Re: PA22-019 – Groundhog PRD –*Incomplete*

Your application has been determined to be ***incomplete*** as of the date of this letter. Please provide the following items, as they are necessary to determine a complete application for processing:

**GRADING AND COMPOSITE UTILITY PLAN**  
GROUNDHOG PLANNED RESIDENTIAL DEVELOPMENT

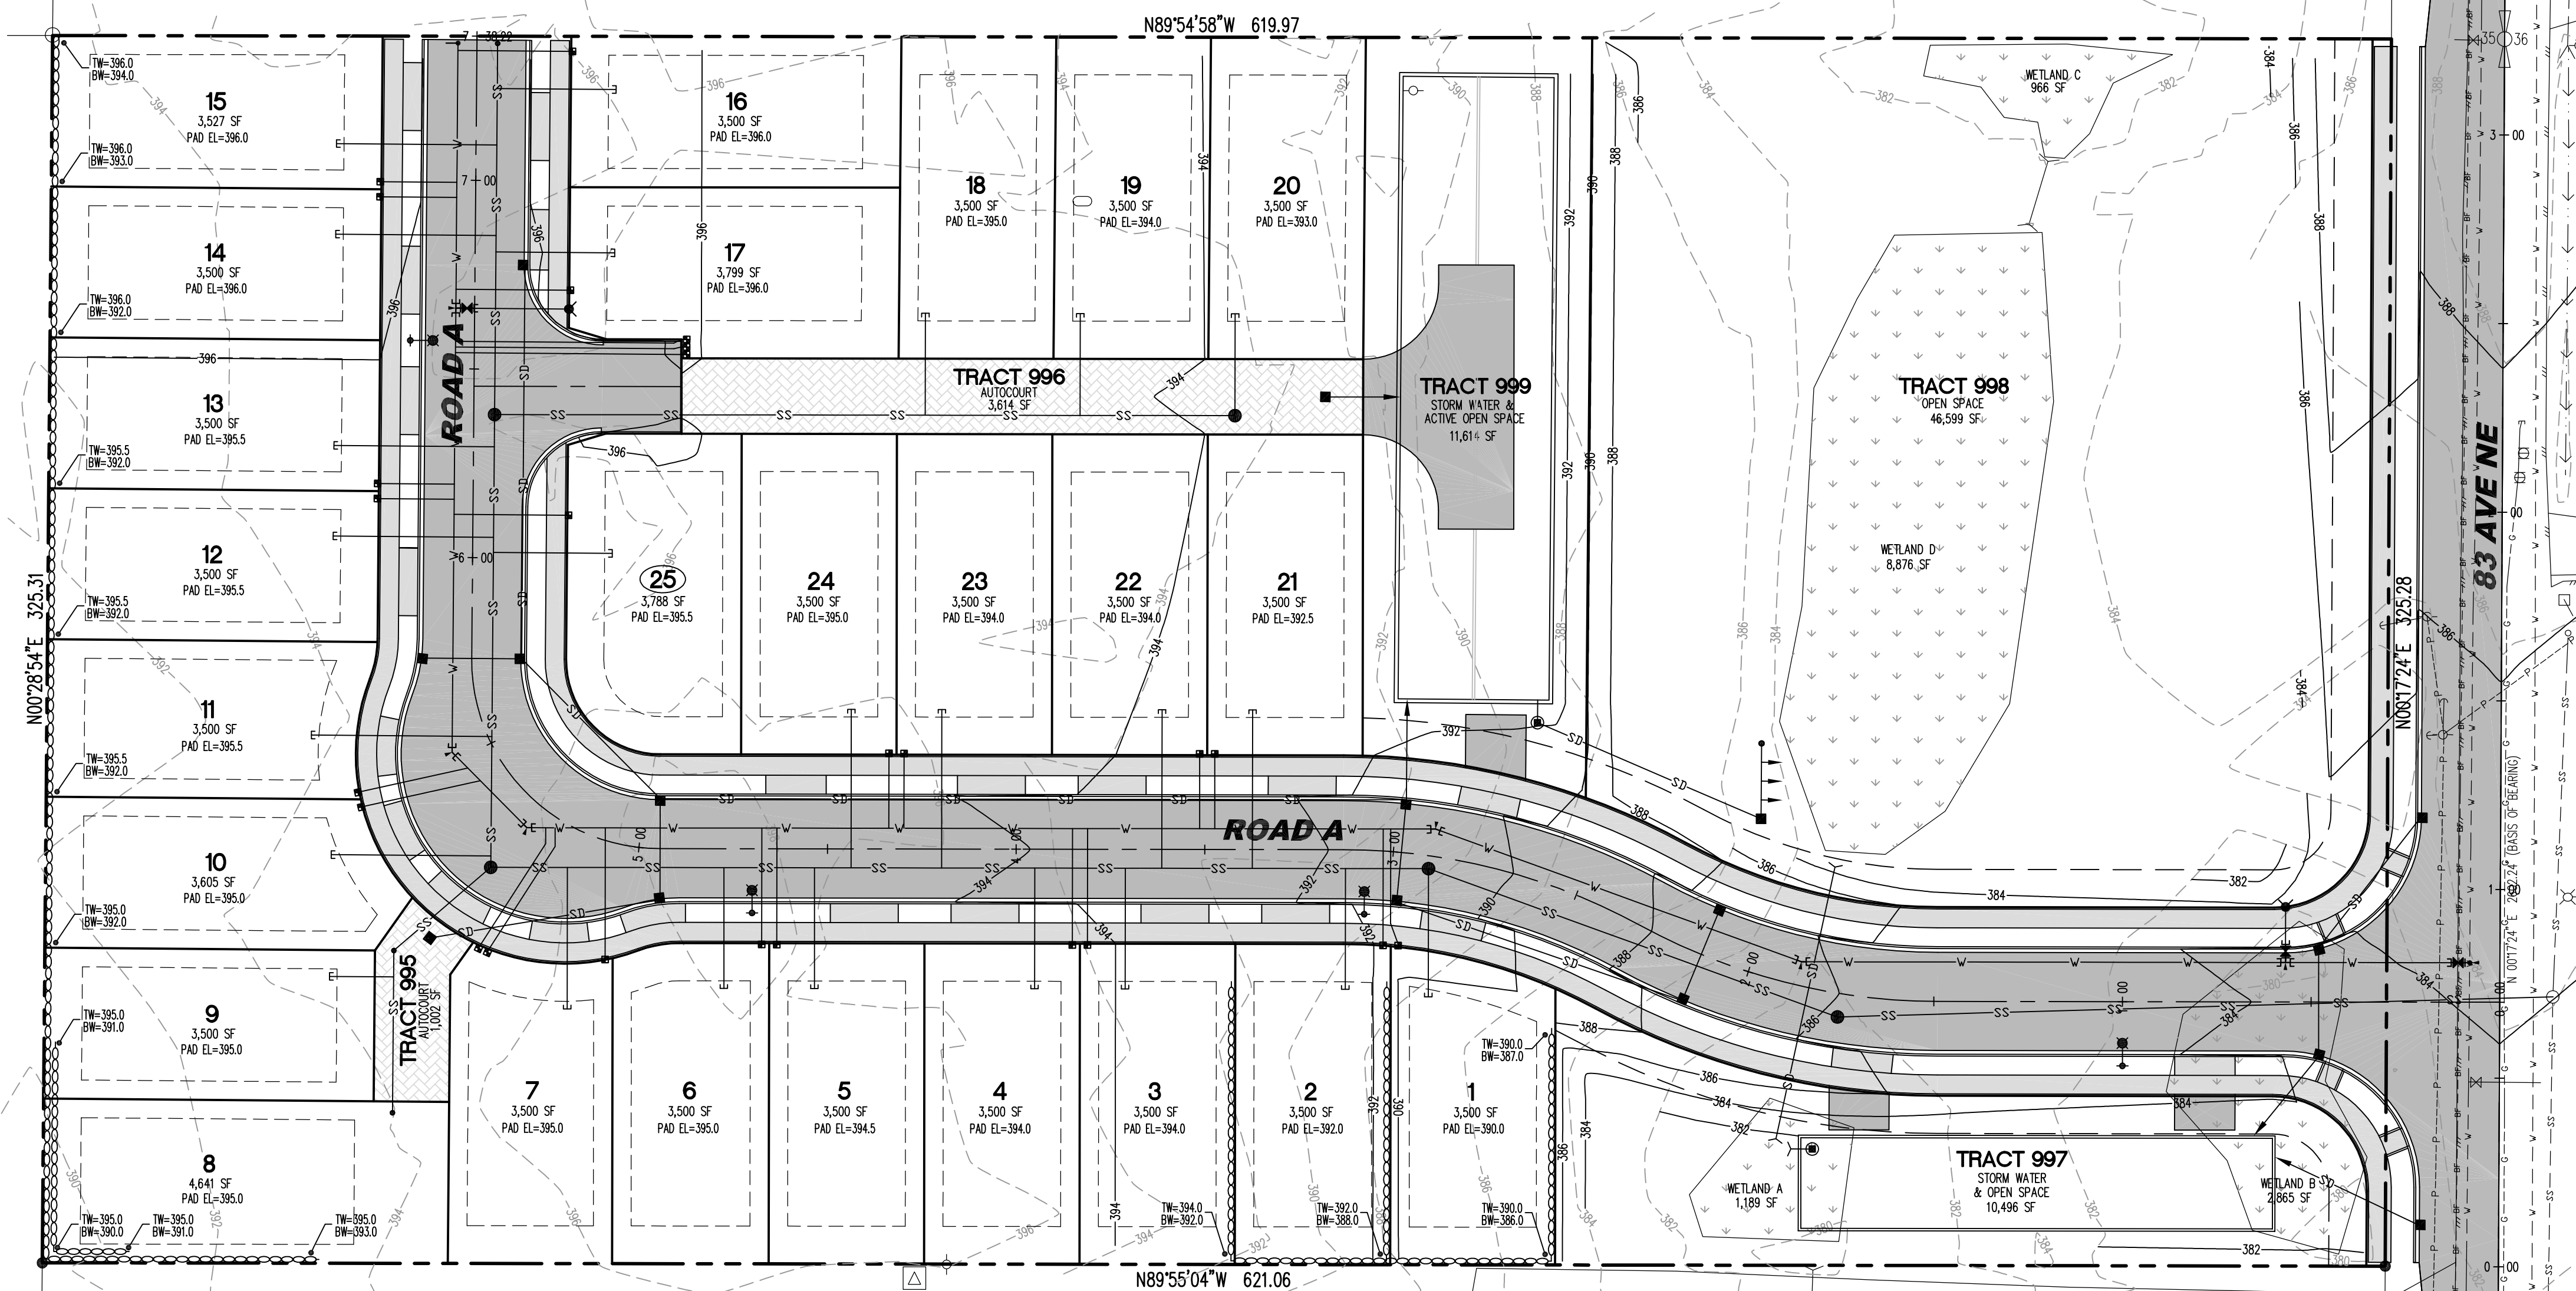
- c. Based on the scope of development, impacts to the wetlands are anticipated, including grading activity within the required buffers. A preliminary wetland mitigation and enhancement plan is required to be prepared in accordance with MMC 22E.010.120 through MMC 22E.010.160.

**Preliminary Landscape Overview**  
Scale: 1" = 30'-0"  
0 10 30 FT

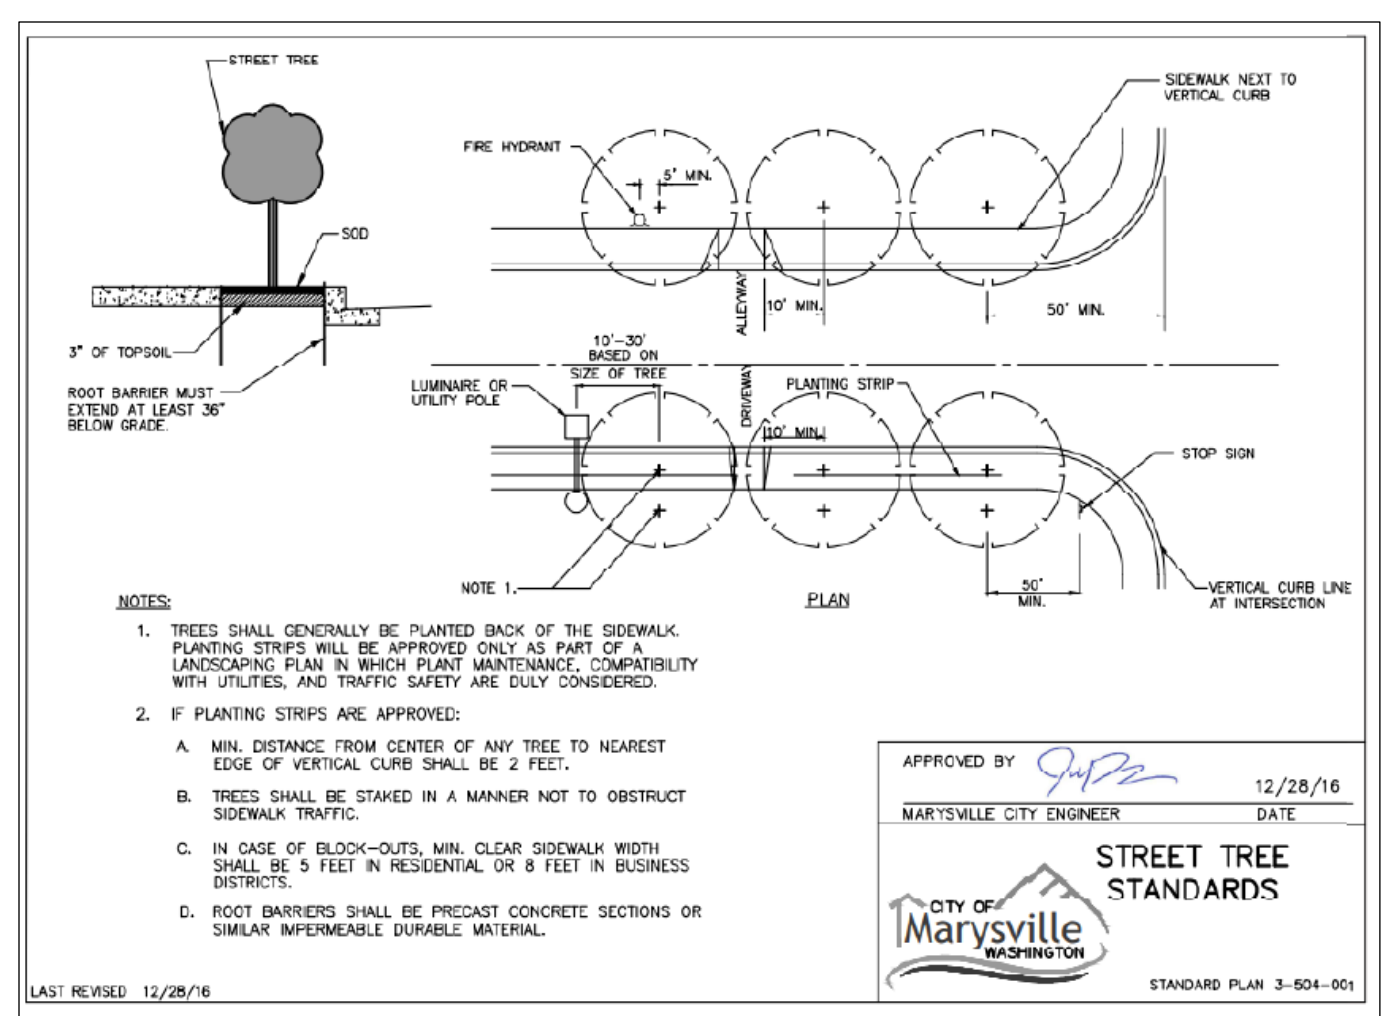
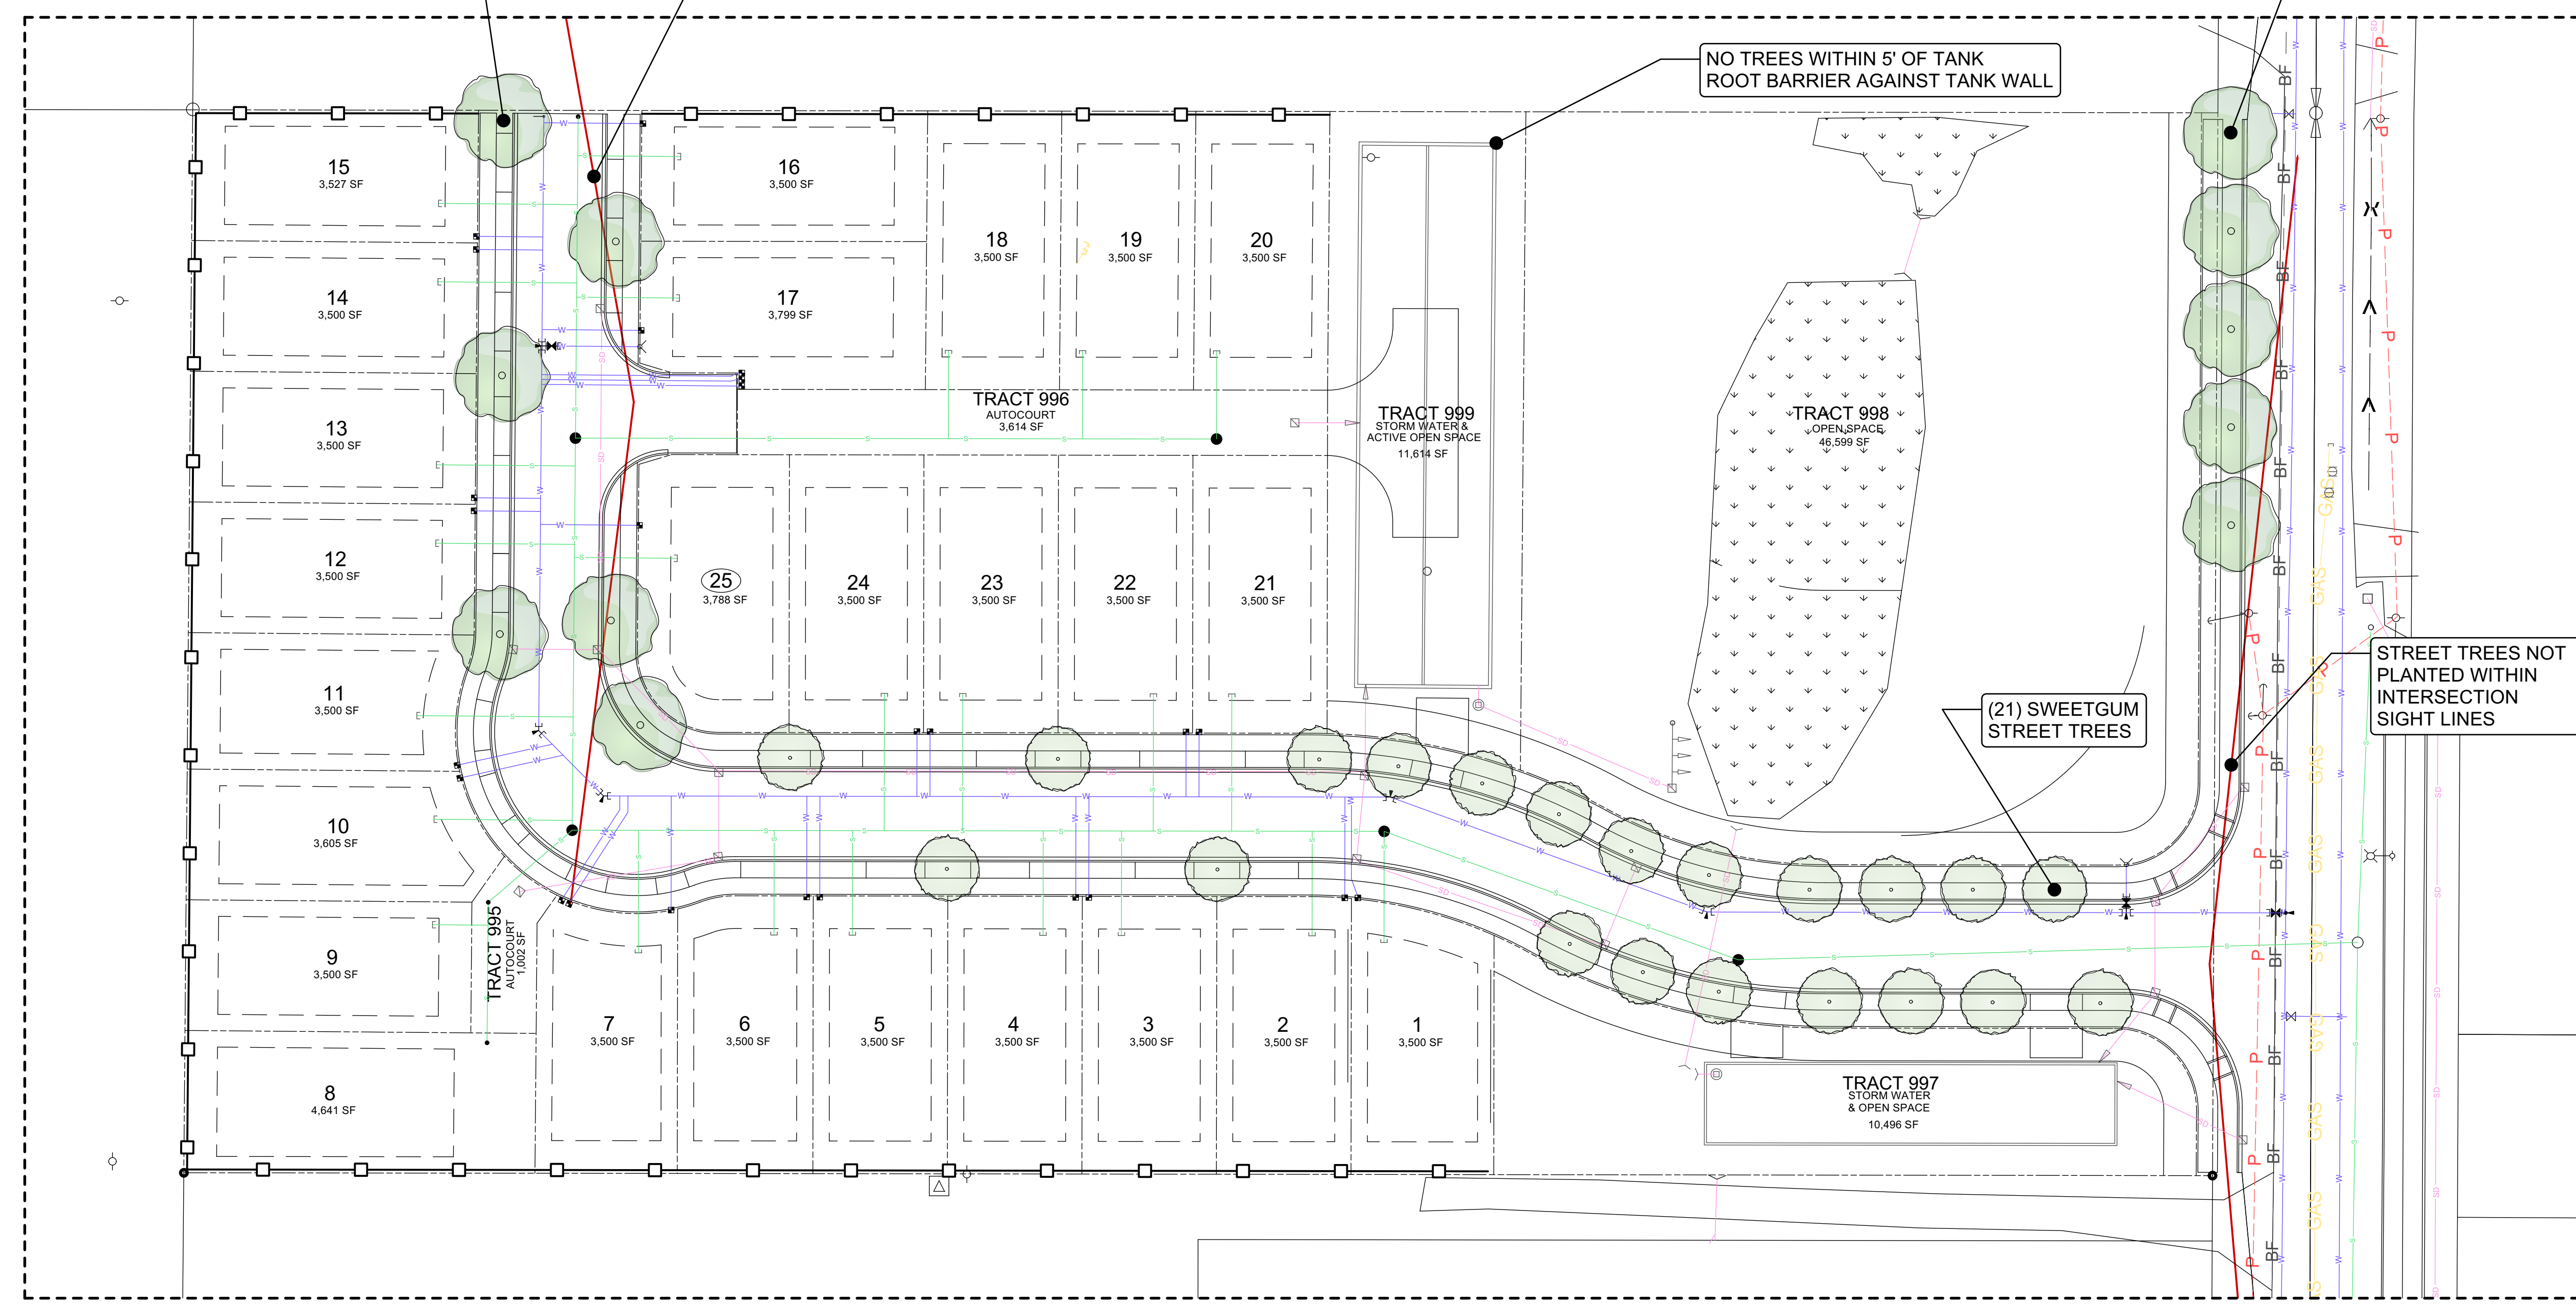
3. As indicated in the project narrative, bonus density is proposed via Residential Density Incentive (RDI) 6a. Clarification is needed to demonstrate compliance with the application of said RDI. As proposed, the active open space does not meet the definition of MMC 22.090.040. Please provide clarification as to what distinguishes the open space as "active".
